WEST SUSSEX COUNTY COUNCIL CONSULTATION

TO:	Arun District Council FAO: David Easton
FROM:	WSCC - Highways Authority
DATE:	23 April 2019
LOCATION:	Land north of Hook Lane, Pagham
SUBJECT:	P/30/19/OUT Outline application with some matters reserved for the construction of up to 300 No. new homes, a care home of up to 80 beds, D1 uses of up to 4,000 sqm including a 2 form entry primary school, the formation of new means of access onto Hook Lane & Pagham Road, new pedestrian & cycle links, laying out of open space, new strategic landscaping, habitat creation, drainage features & associated ground works & infrastructure. This application may affect the setting of a listed building & is a Departure from the Development Plan (resubmission following P/6/17/OUT).
DATE OF SITE VISIT:	As part of P/6/17
RECOMMENDATION:	More Information
S106 CONTRIBUTION TOTAL:	£ See below for breakdown.

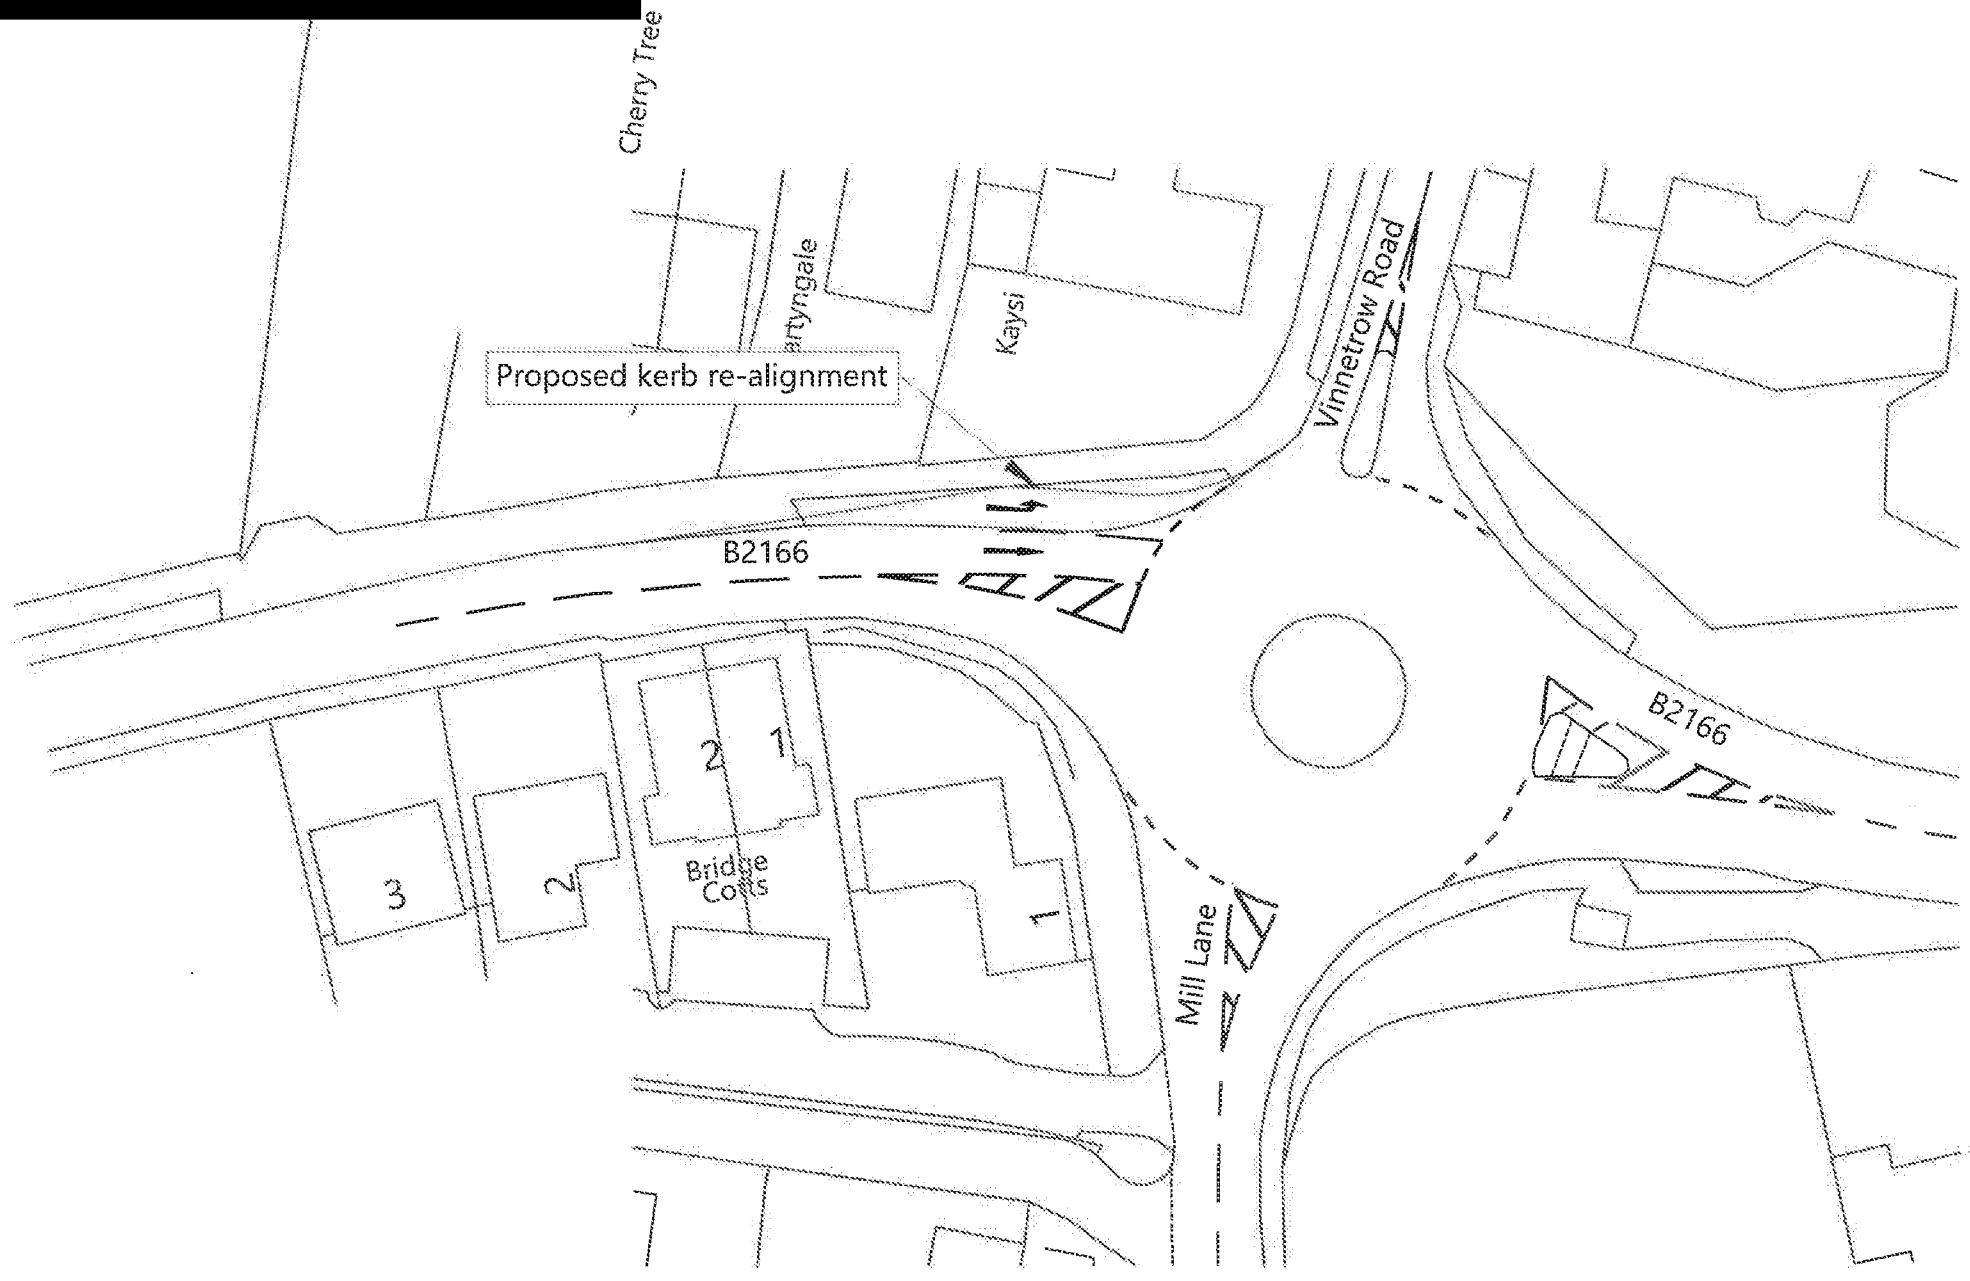
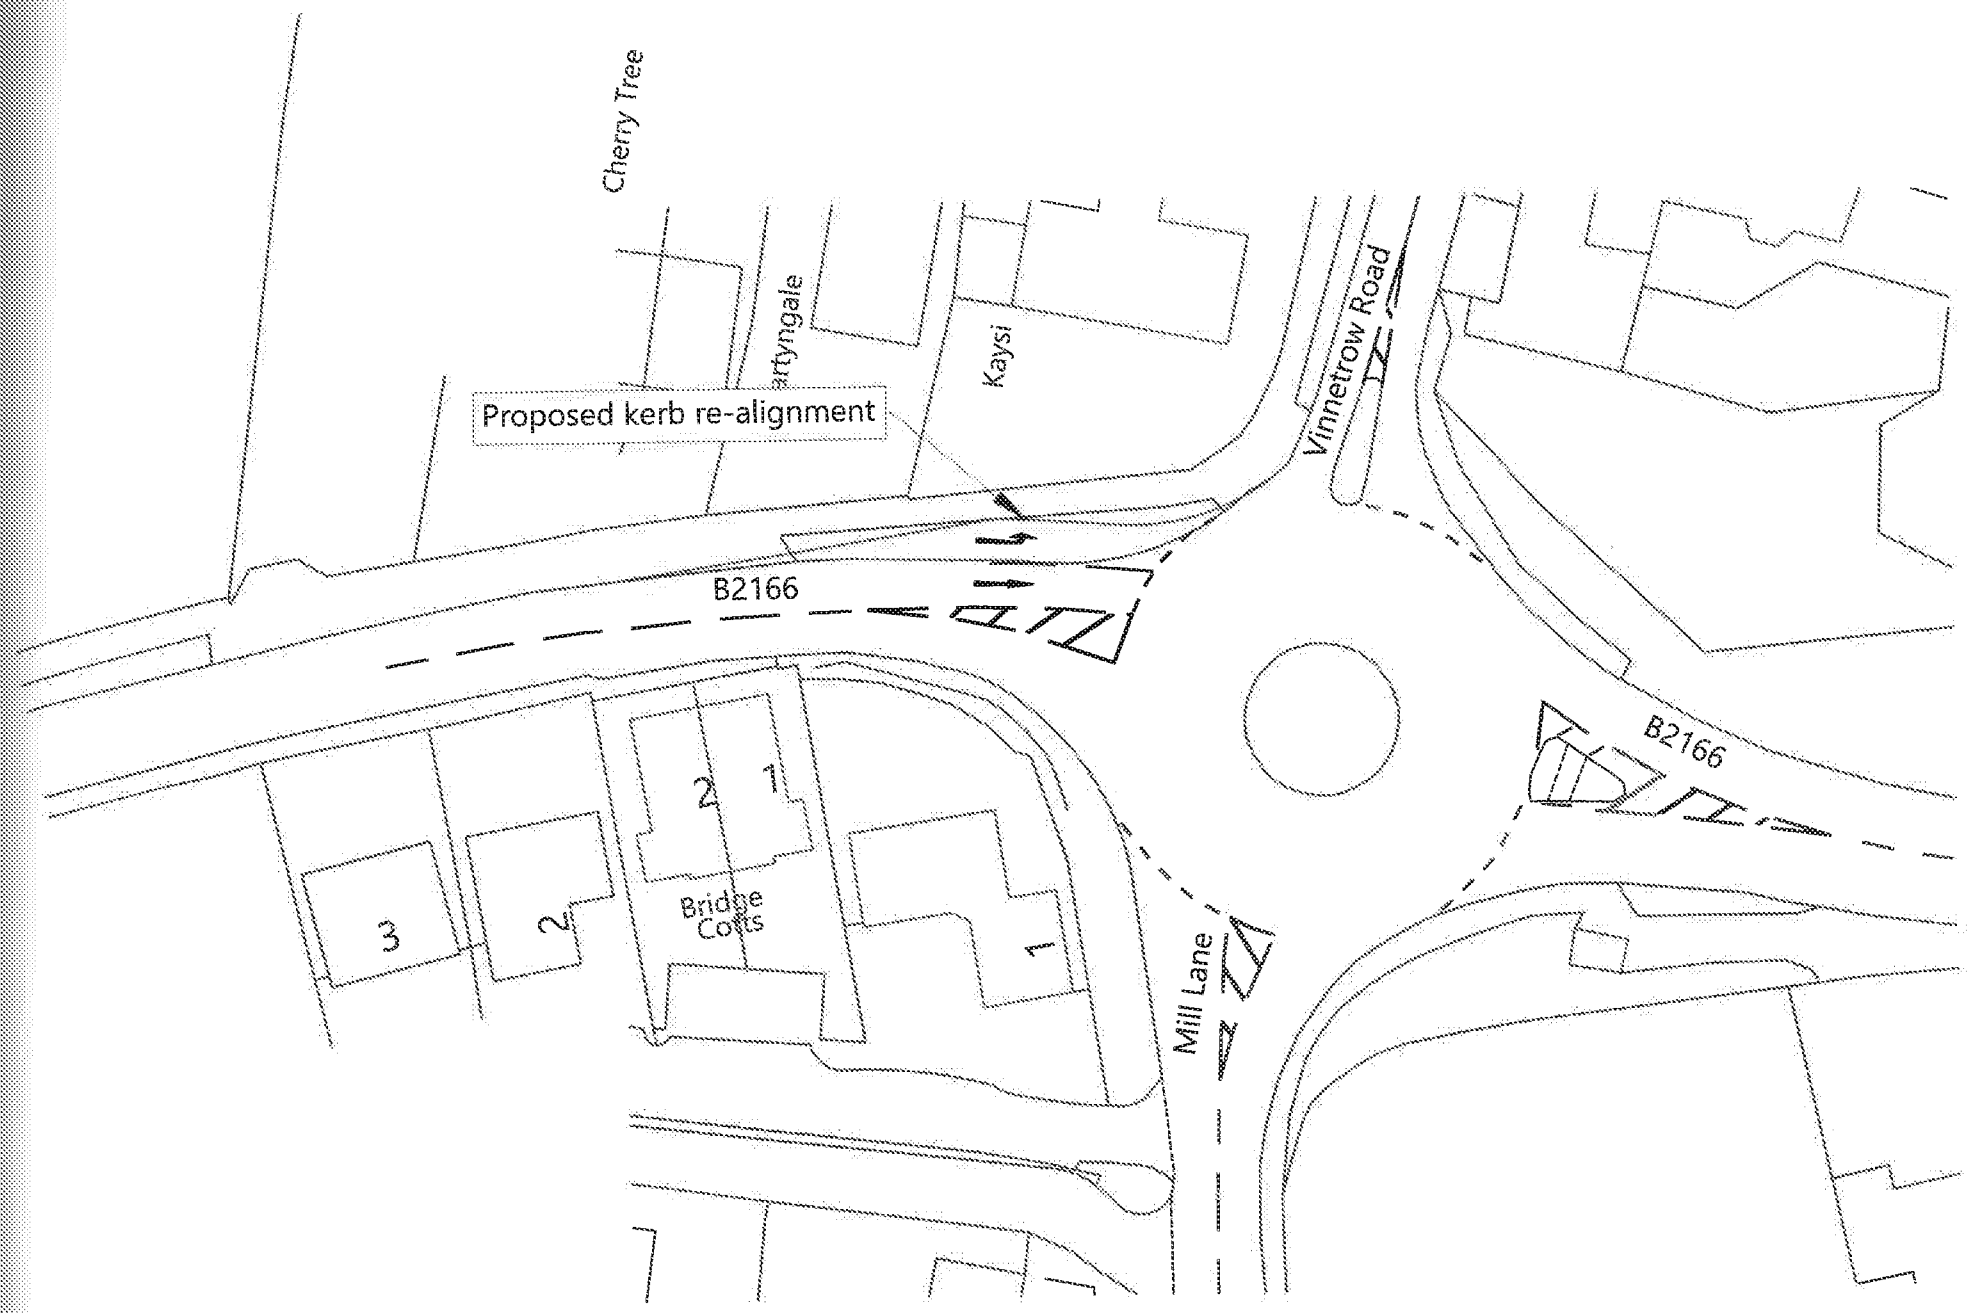
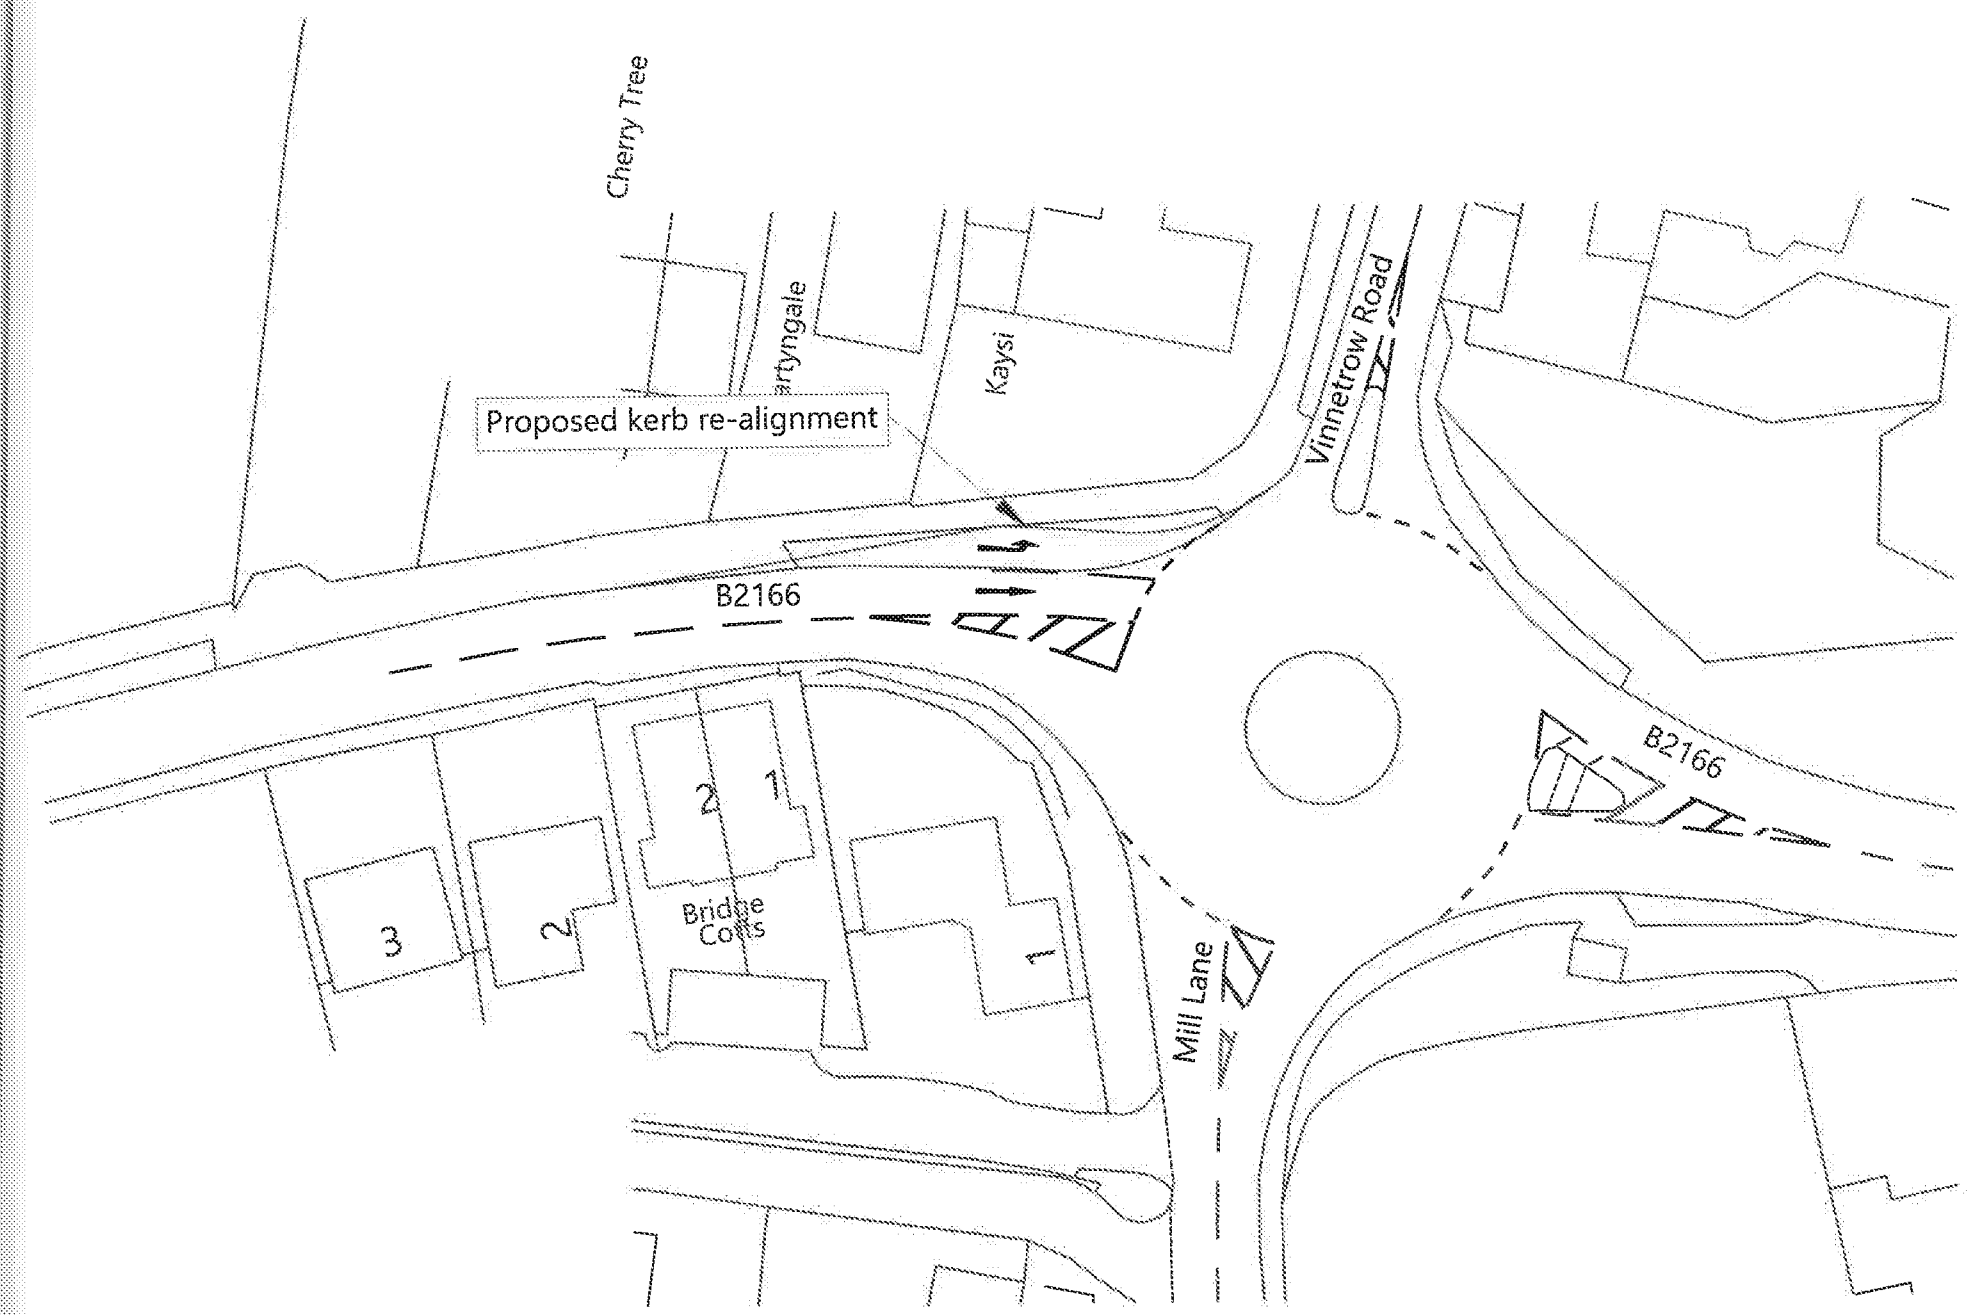
3. The development is to take vehicular access from Pagham Road and Hook Lane. All accesses are to take the form of simple priority junctions. Two accesses are to be provided on Hook Lane with a further single access onto Pagham Road. This arrangement reflects that submitted initially with P/6/17.
4. Whilst there is no objection to the three accesses, there appears scope to rationalise and remove the more southerly Hook Lane access; this access was removed as part of P/6/17. This access is unlikely to be used by any significant volume of traffic in light of the location of the northerly Hook Lane and Pagham Road accesses. It would be requested for consideration to be given to reducing the number of access points onto Hook Lane.

6. In checking the stopping sight distances at the two Hook Lane accesses against the recorded speeds, the sightlines appear to exceed those typically required using MfS Stopping Sight Distances. On this basis, the LHA are satisfied that adequate visibility can be achieved onto Hook Lane within land forming part of the adopted highway and/or land under the control of the applicant. The geometry in all other respects appears acceptable and complies with current guidance.

8. Based on the recorded 85th percentile speeds and the DMRB, SSDs of 152 metres to the south and 149 metres to the north are required. These are demonstrated from an X distance of 4.5 metres. The distances are considered acceptable and can be achieved within land forming part of the adopted highway and/or under the control of the applicant.

9. The vehicle access arrangements have been reviewed by way of a Stage One Road Safety Audit. Whilst appreciated that the Audit was accepted previously, the standards on which RSAs are undertaken has been updated. The Audit should be updated so as to comply with the latest RSA standards.
